**Town & Country Planning Act 1990 (as amended)
Town & Country Planning (Development Management Procedure) (England) Order 2015
Application for Planning Permission for Works or Extension to a Dwelling**

Development Demolition of front garage and erection of single storey front extension, side chalet extension, rear chalet extension and side & rear single storey extension.

Location The Studio Cypress Way Aldwick

sheet 1 of 5

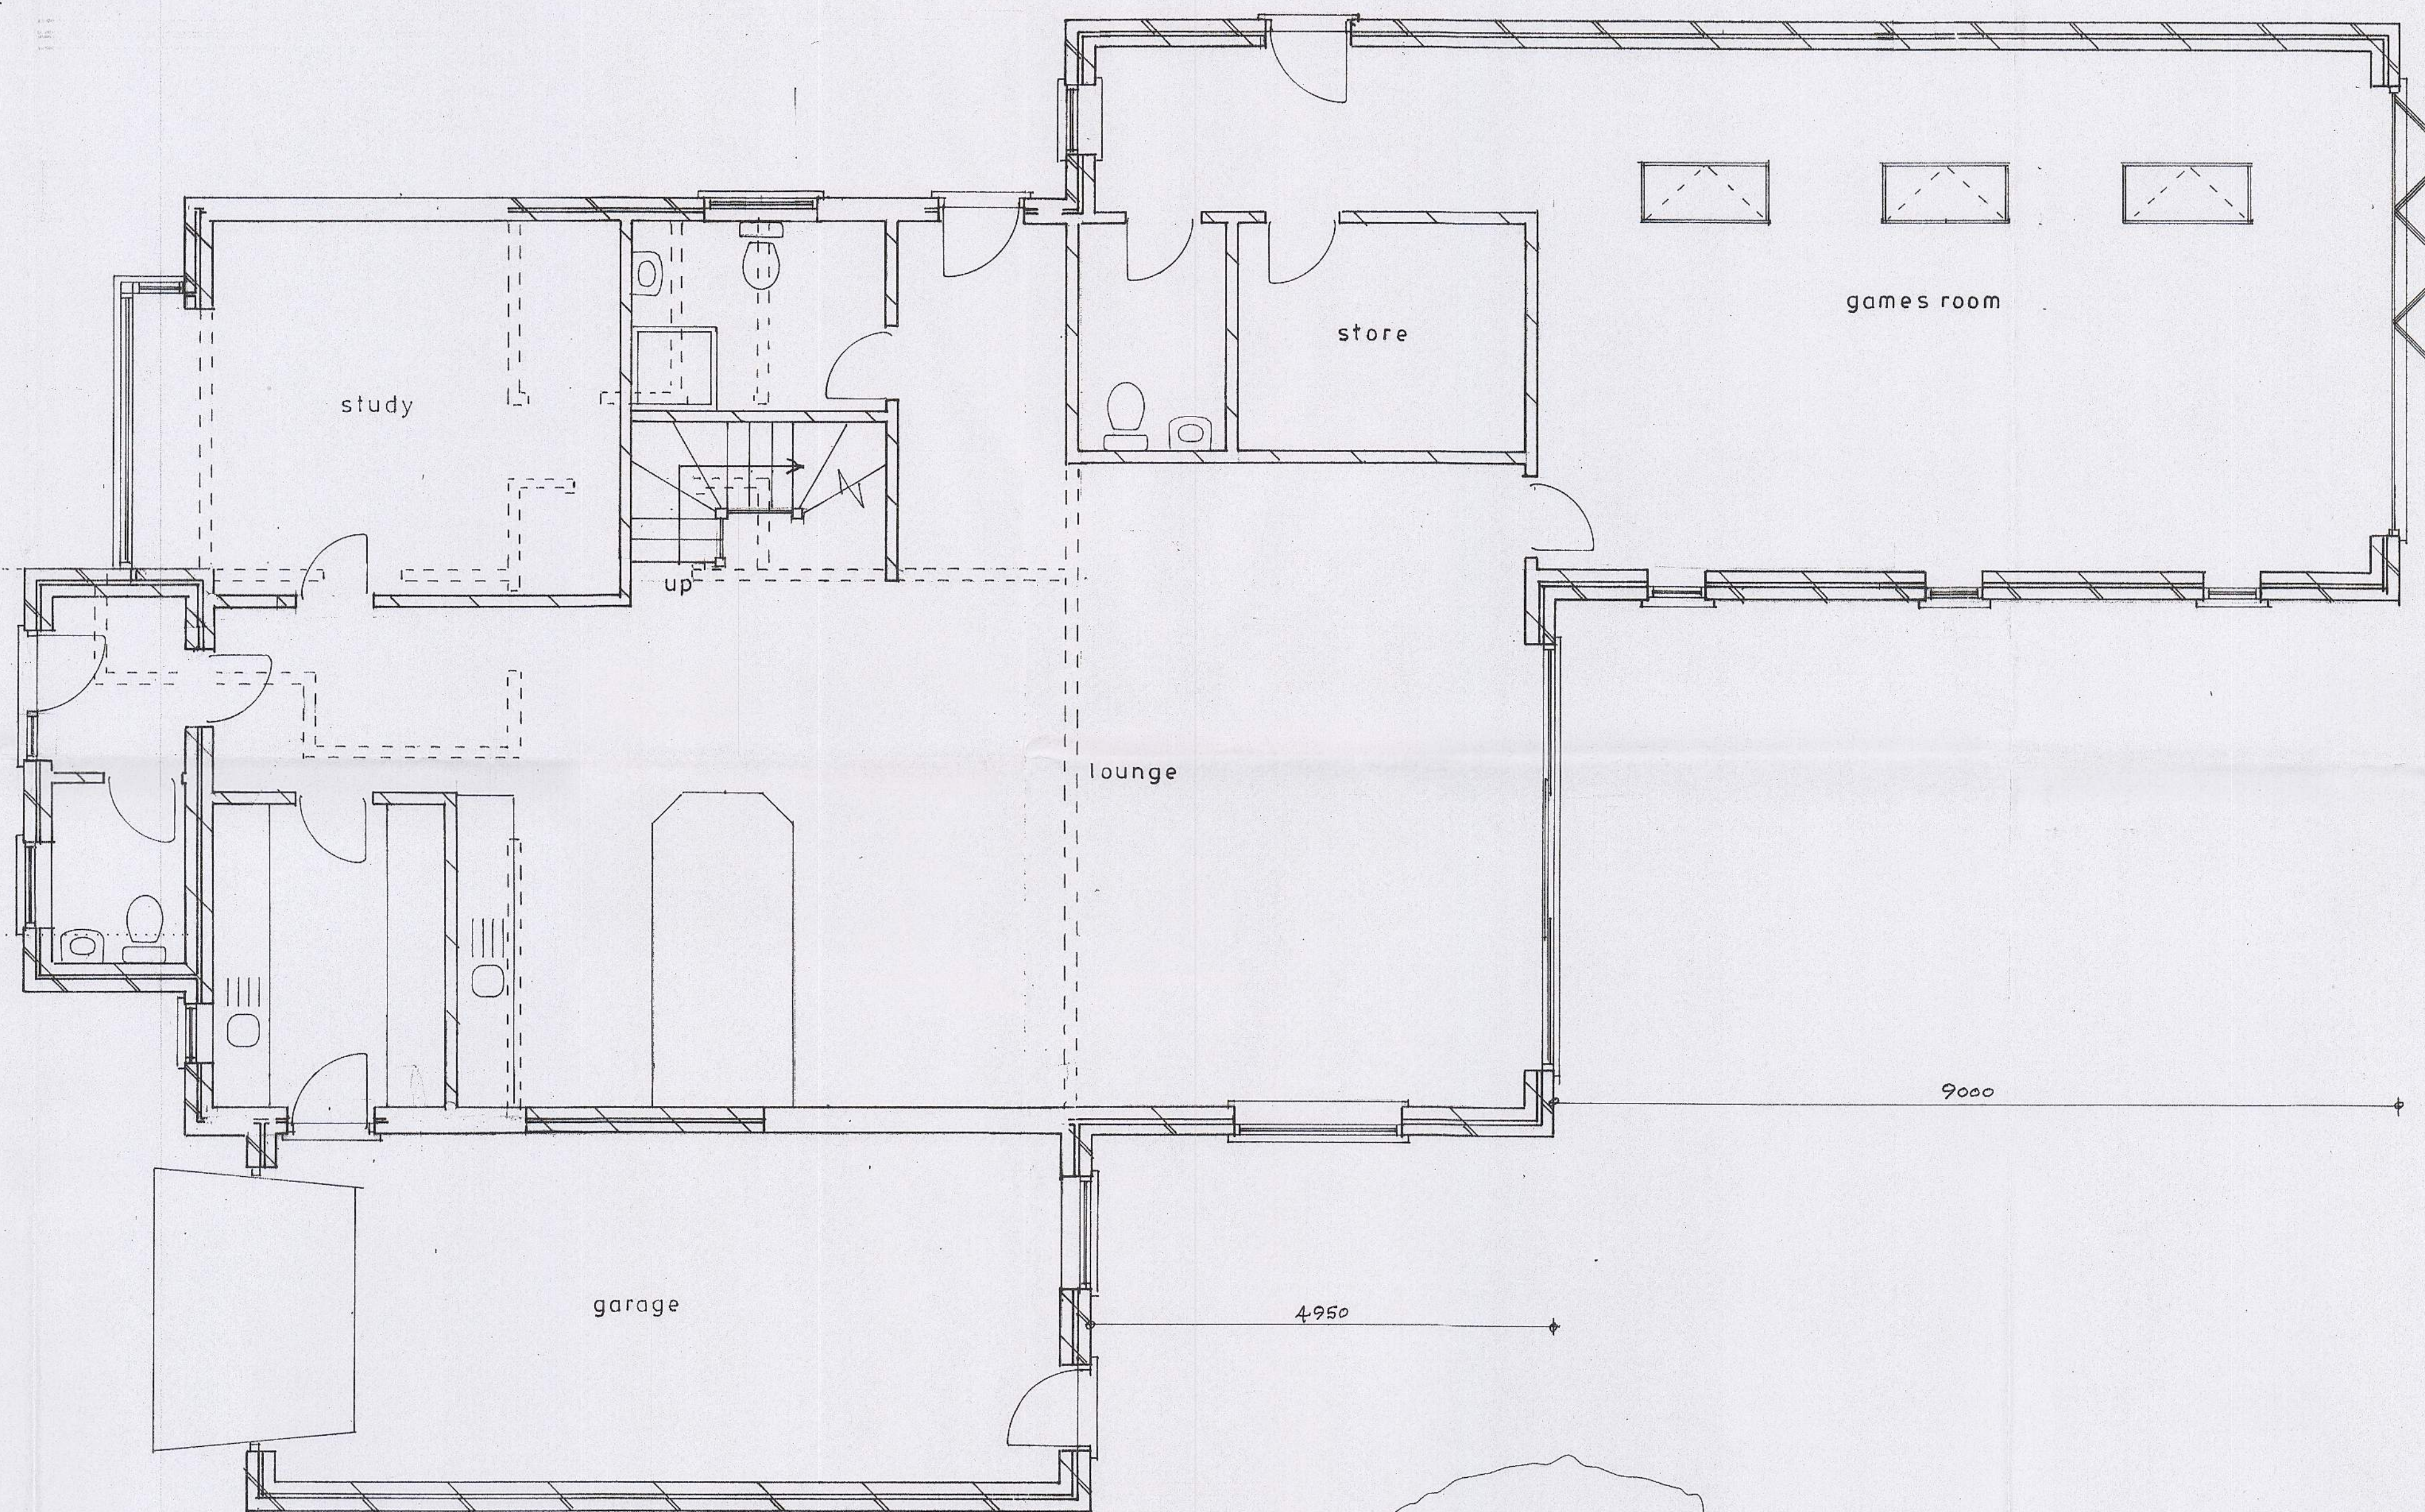
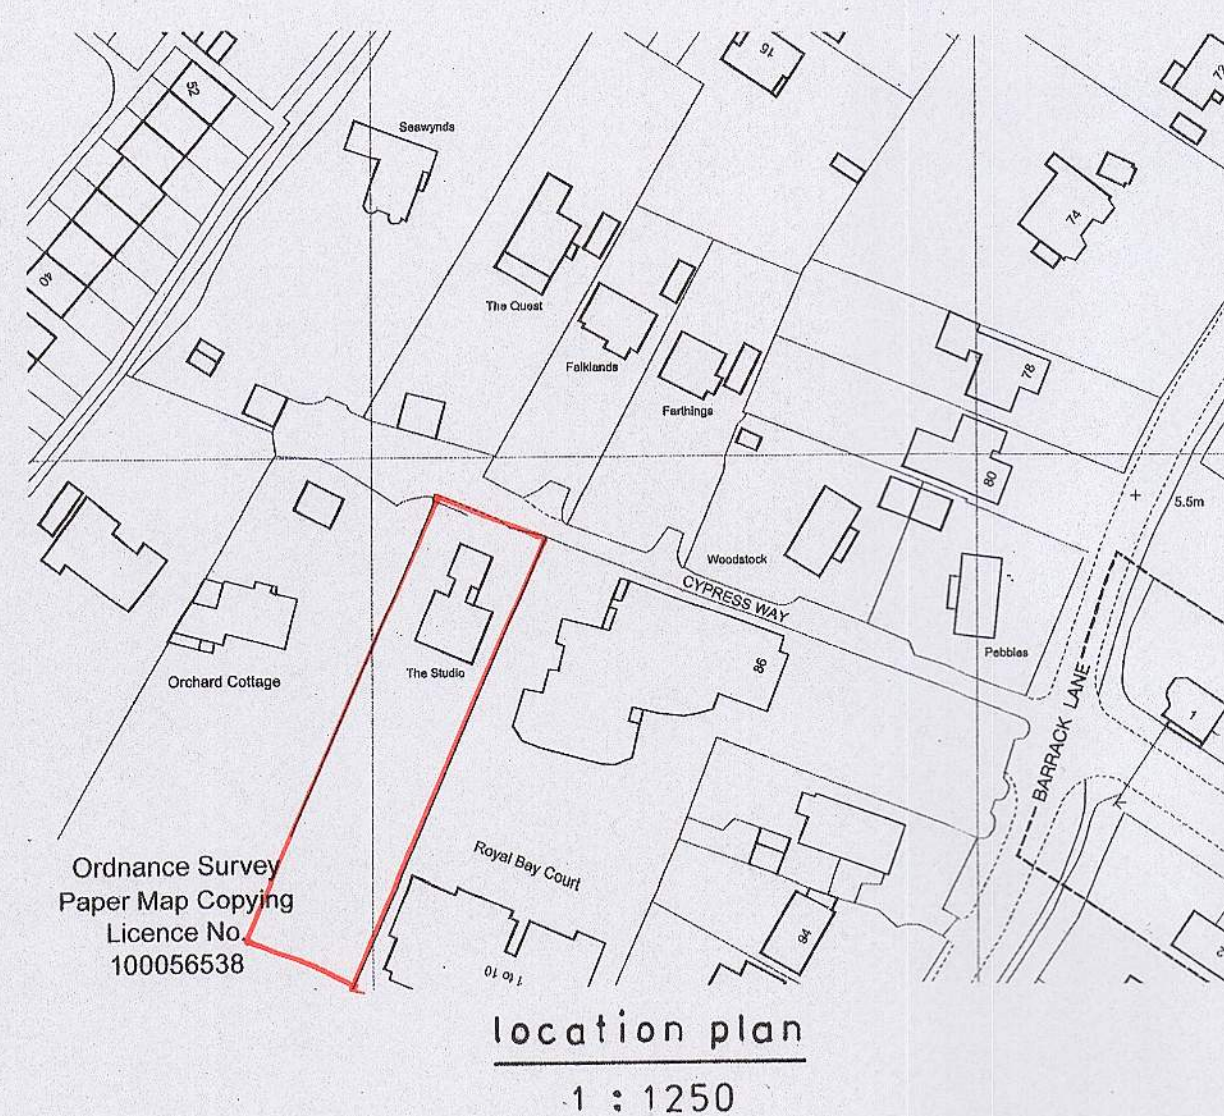
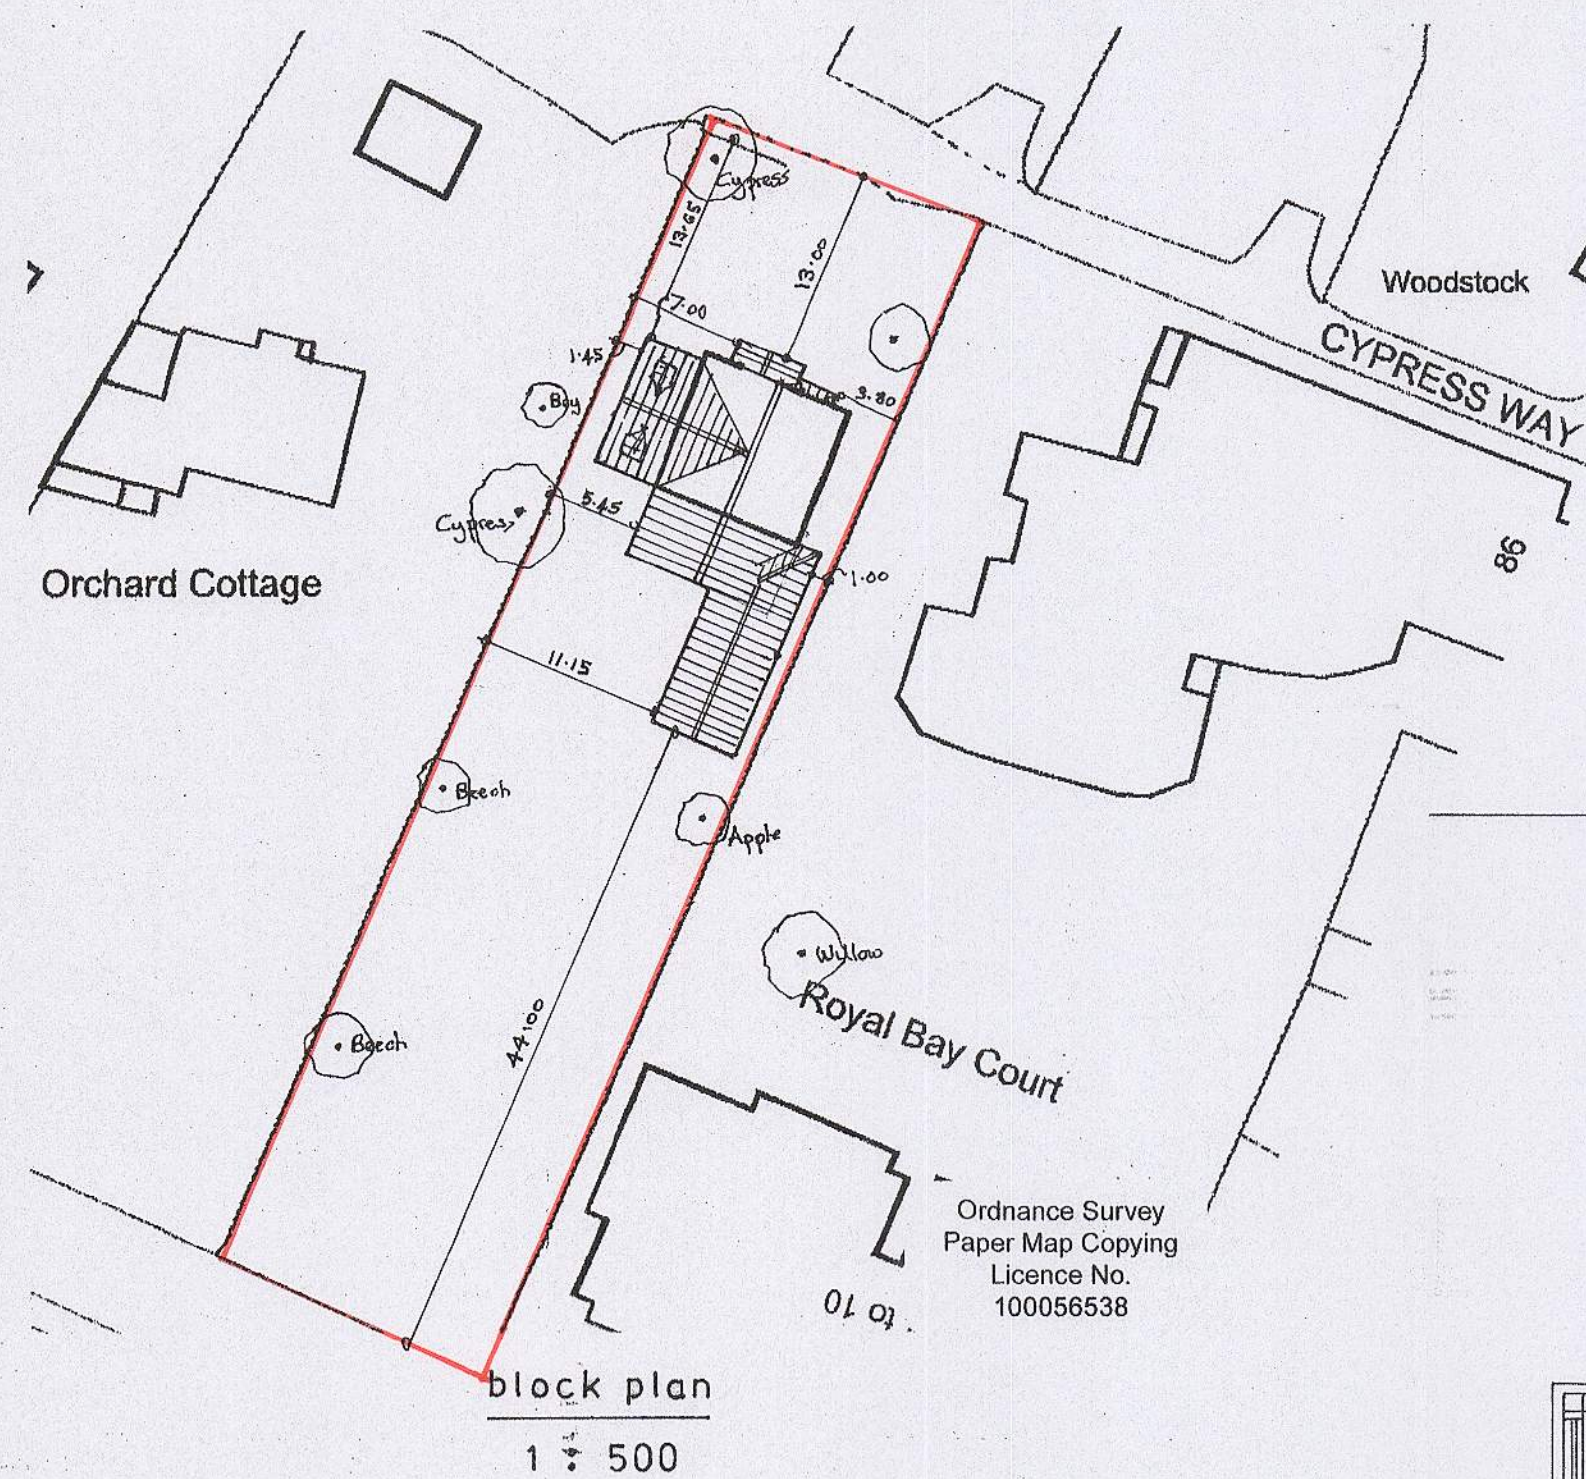
The GF east elevation & ground floor plan do not accord. Please forward amended plans accordingly
